AGG

4th March 2011

RETROSPECTIVE PLANNING APPLICATION H/1/11

Elevations Proposed

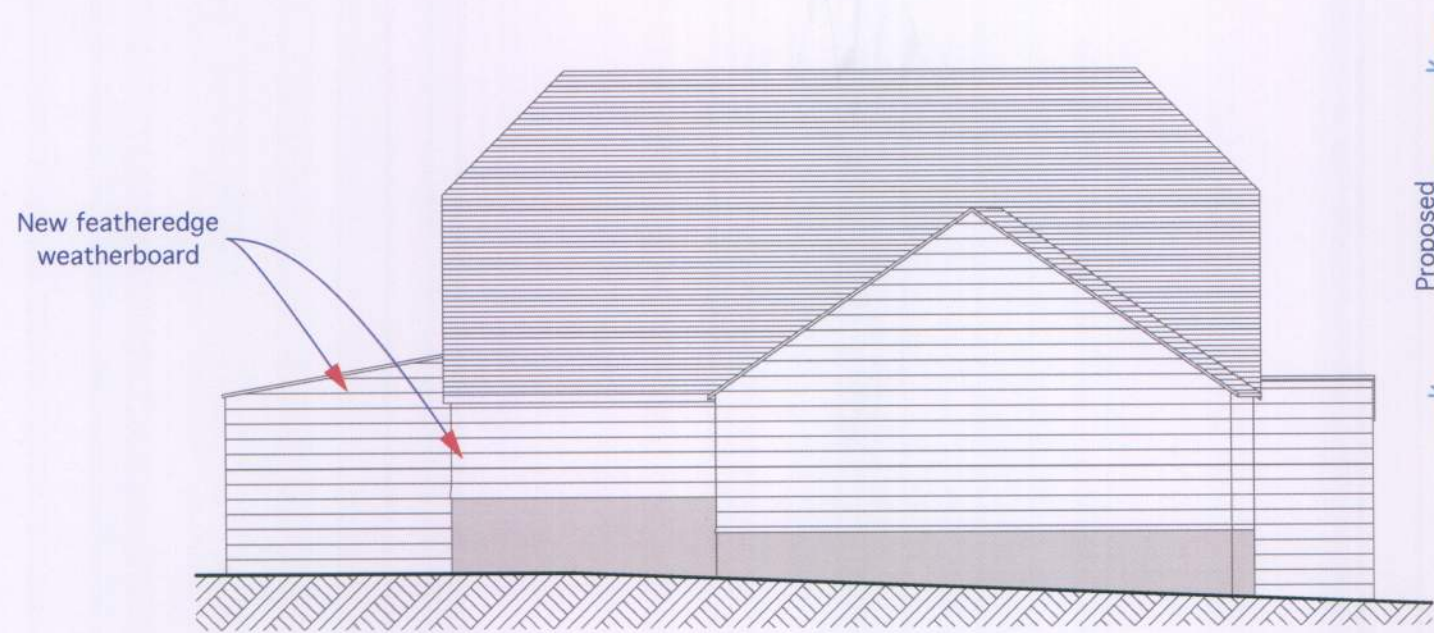
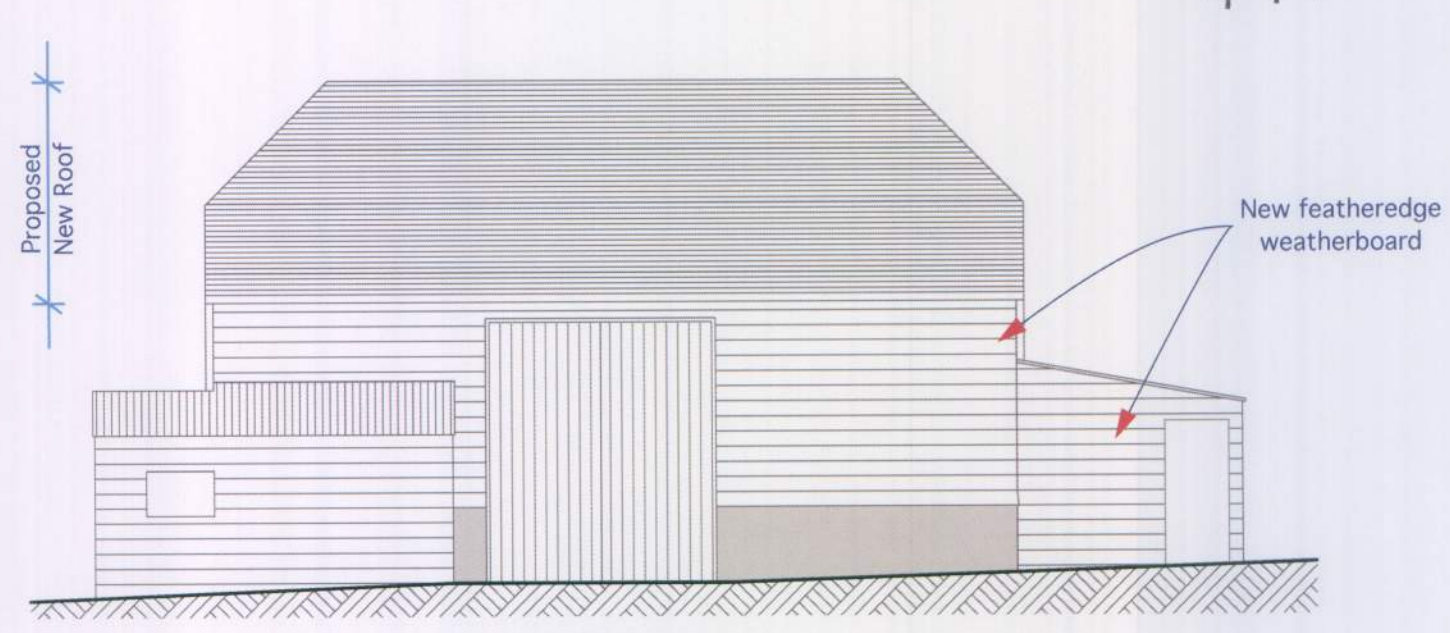
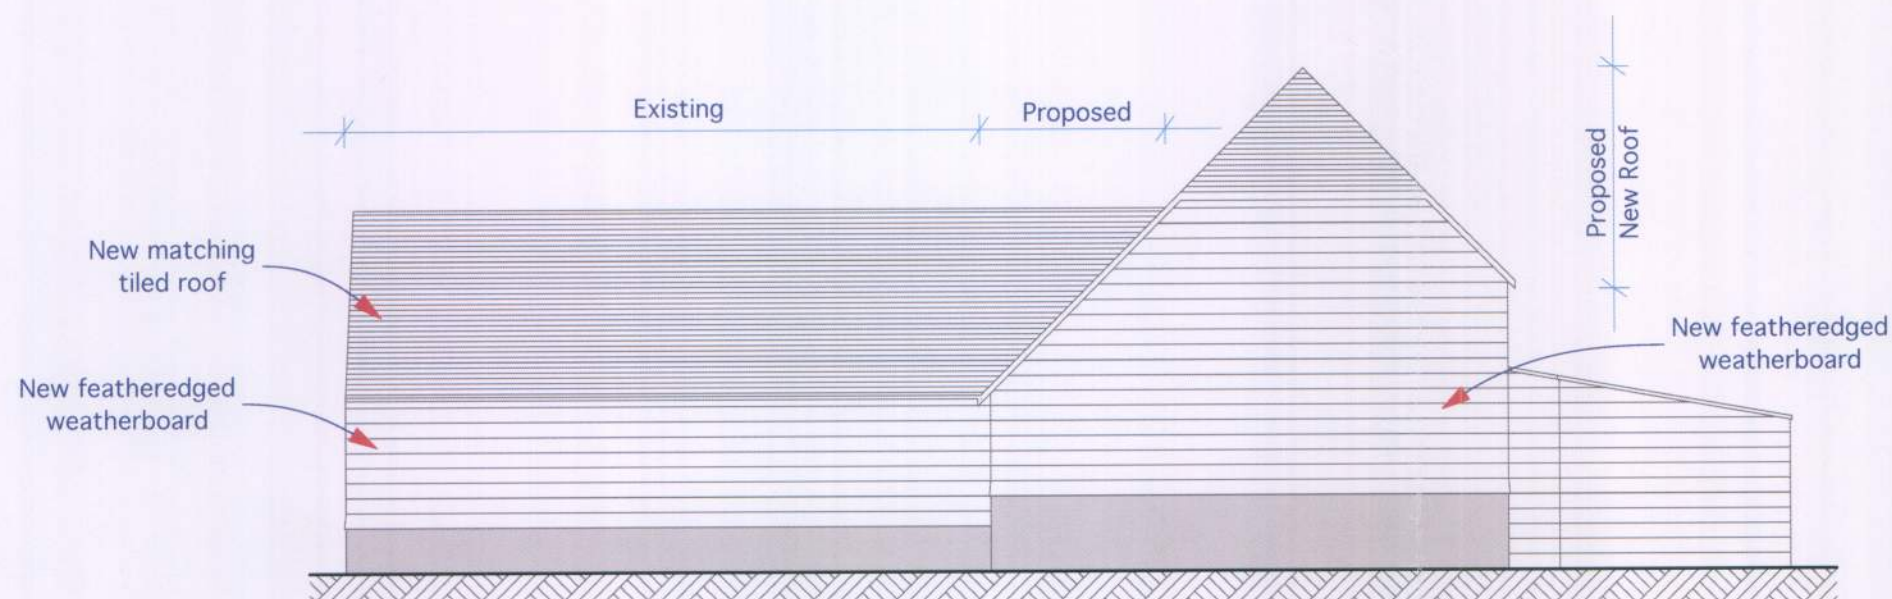
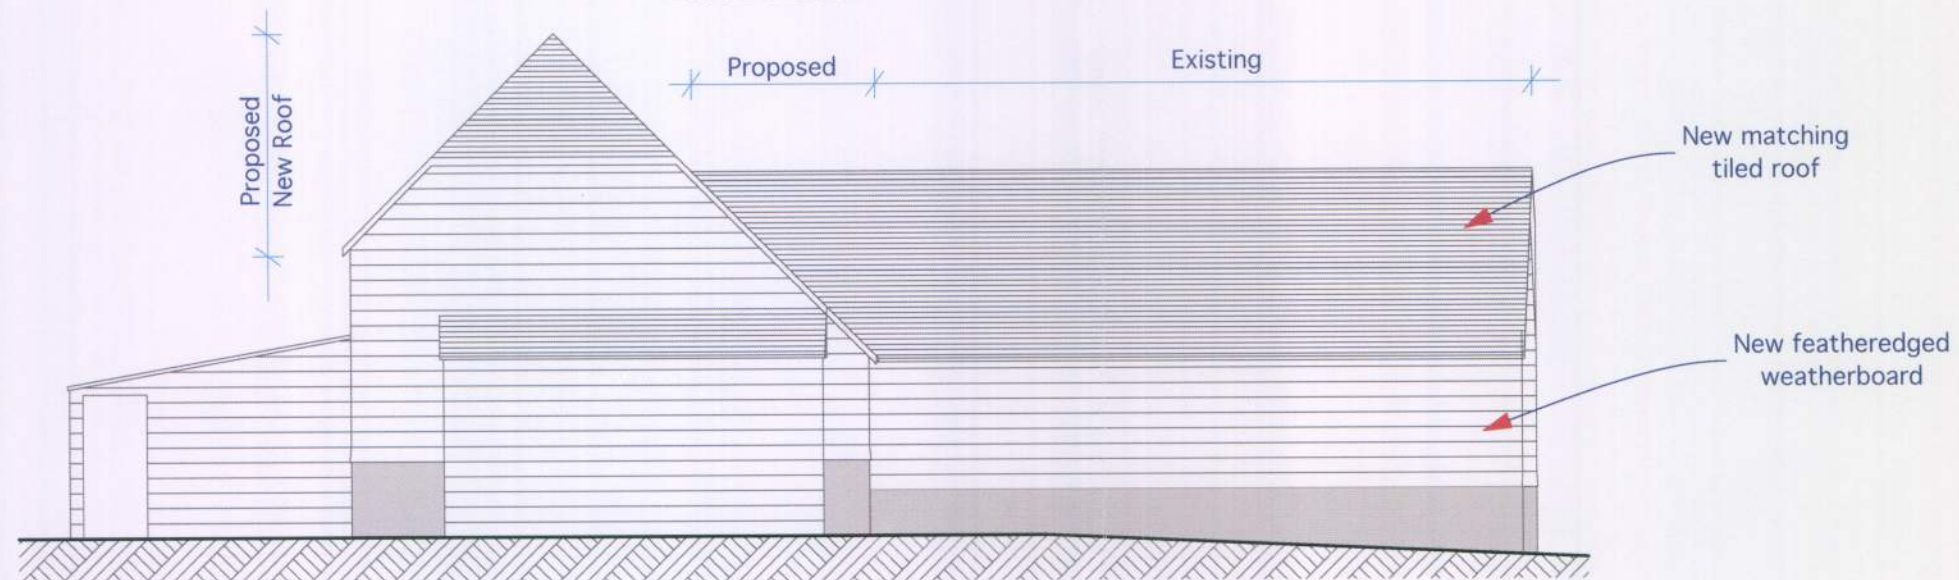
I have received a number of comments from residents of South Lane regarding this application all of which relate to the overall height of the roof line compared with the original building. I am also concerned because according to the plans the new roof is some 4.5 feet higher than the original. The proposed roof line for the rear building also appears to be higher than the current one.
